## Jeanie Bourke - Re: 30 Monument St. Bp#2014-02773

**From:** Jeanie Bourke  
**To:** Brewster Buttfield  
**Date:** 3/6/2015 1:29 PM  
**Subject:** Re: 30 Monument St. Bp#2014-02773  
**CC:** George Froehlich; Jamie Isaacson; Tammy Munson; Tom Landry

Thank you for providing these changes and details. I have reviewed the information, see my comments below in red. This will need to be submitted formally as an amendment to the original permit. The application is the Residential Alterations/Additions, and you can reference the permit in the description along with the additional changes.

MONUMENT STREET  
30 MONUMNET STREET  
PORTLAND, ME

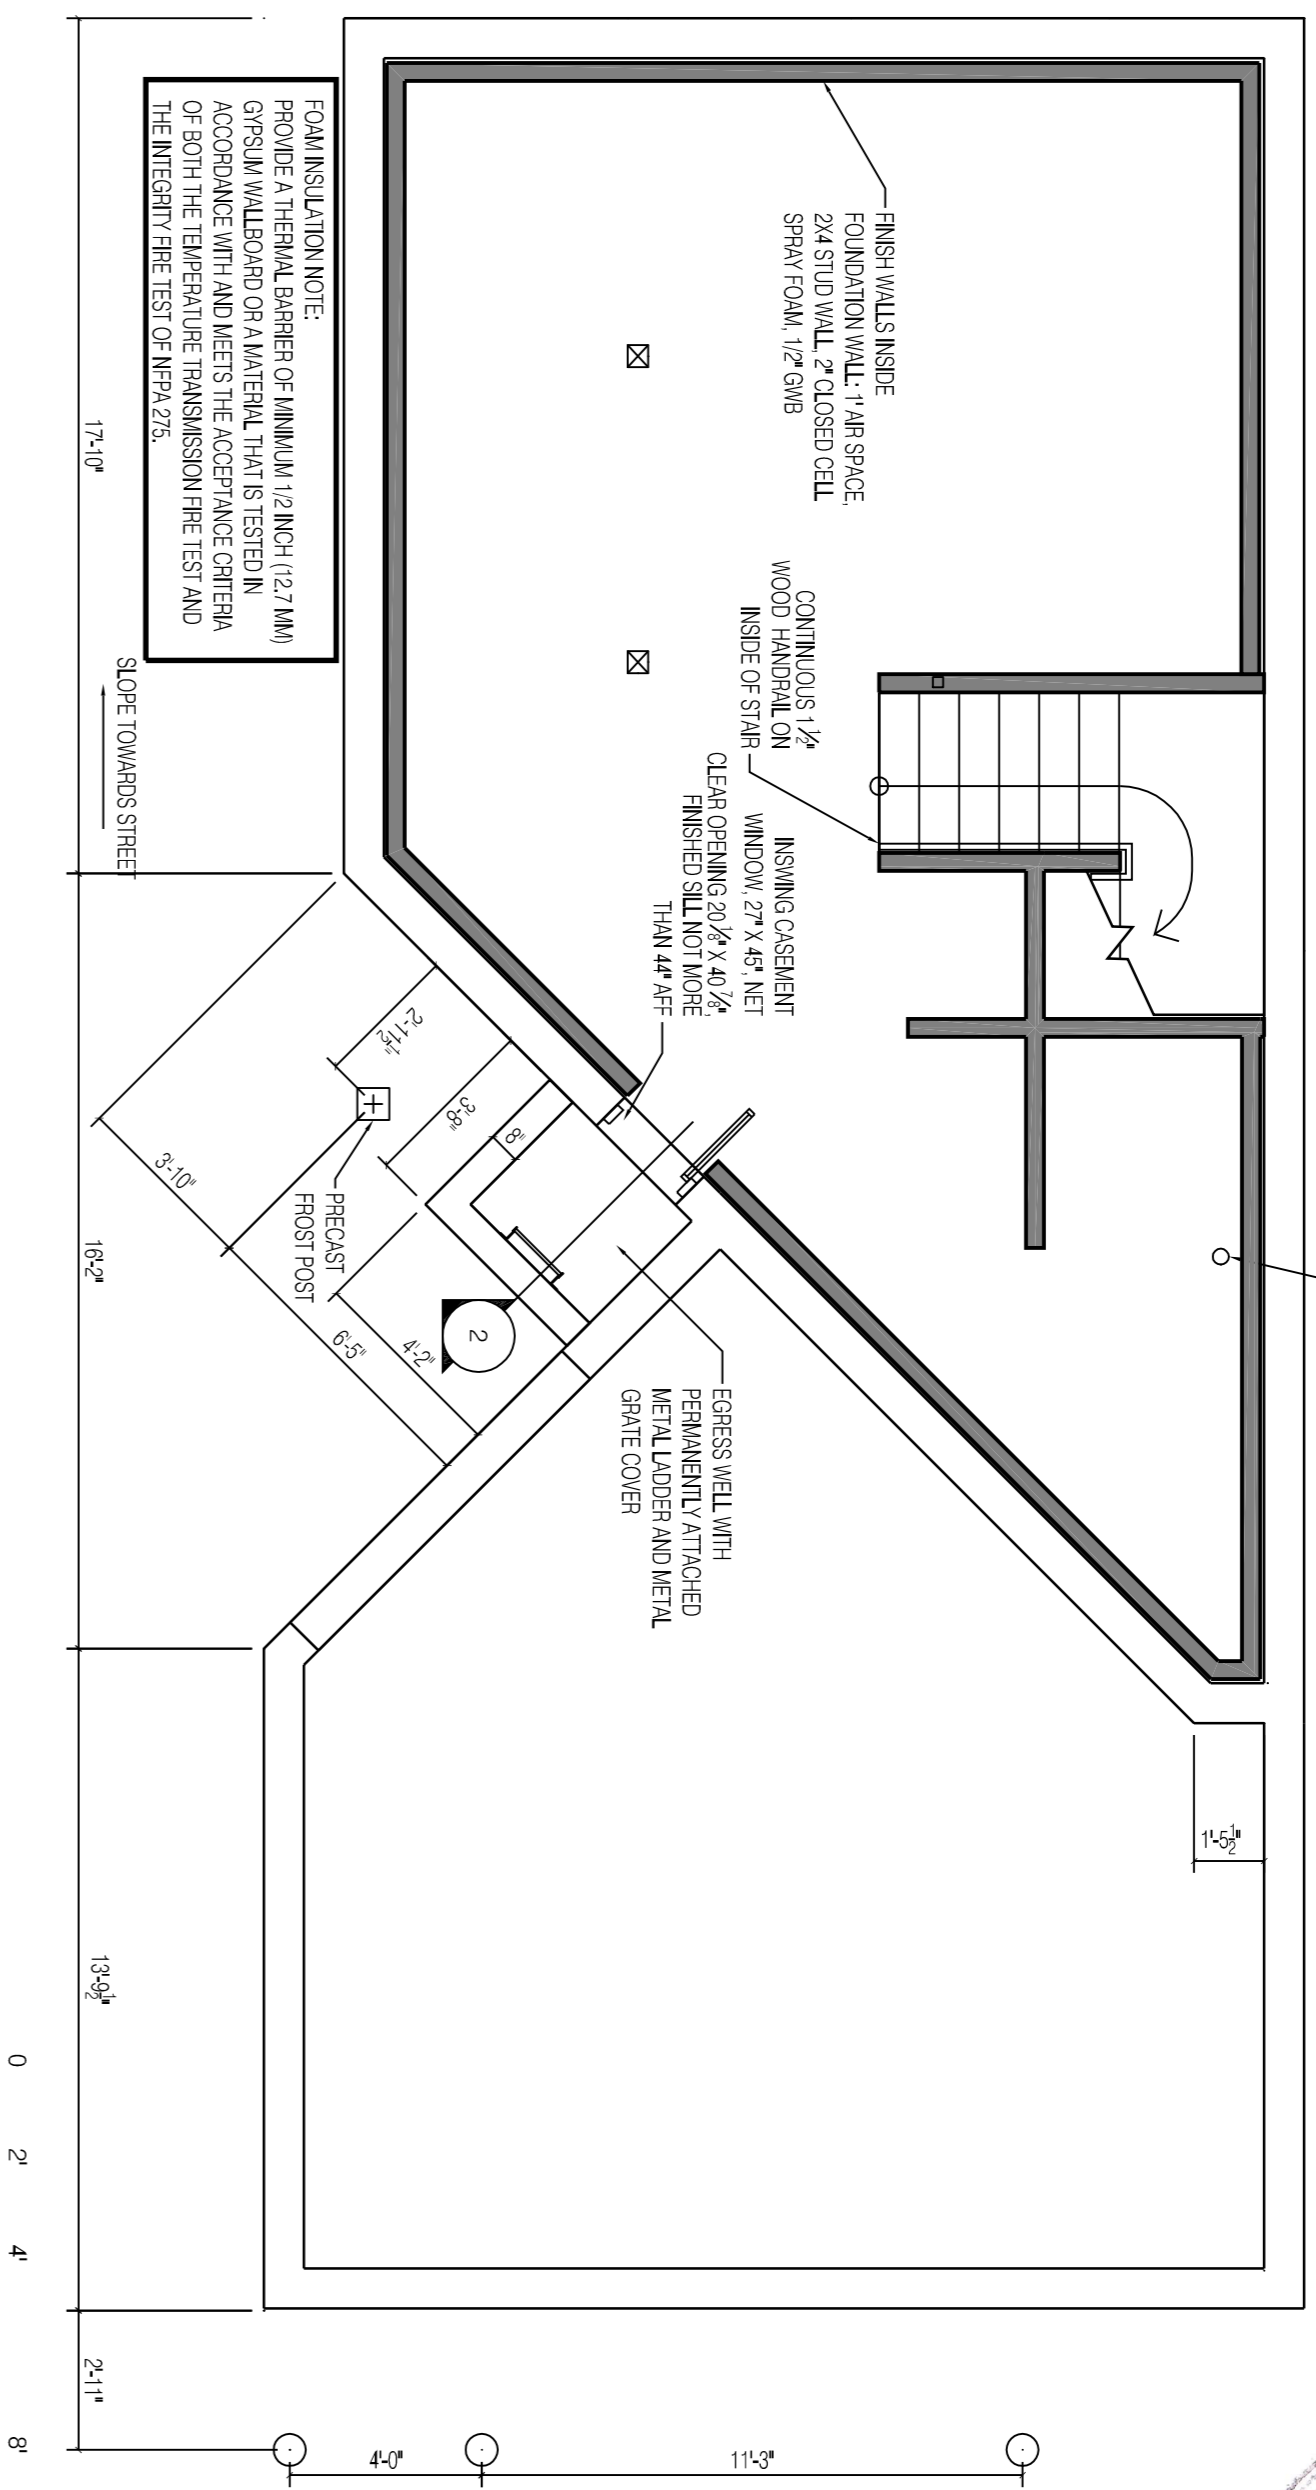
3. An updated plan for the deeper basement is a new sheet, A-103. It shows the required egress well, the stairs to basement instead of a hatch and the required thermal barrier for the insulation. This, as well as any other changes need to be updated on all associated plans, ie. sections, etc.

3. Based on the field inspection by George for the footings, it was confirmed with the contractor that the house will have a full basement. If this is correct, an amendment is required for this change and should include the access and emergency escape and rescue opening.
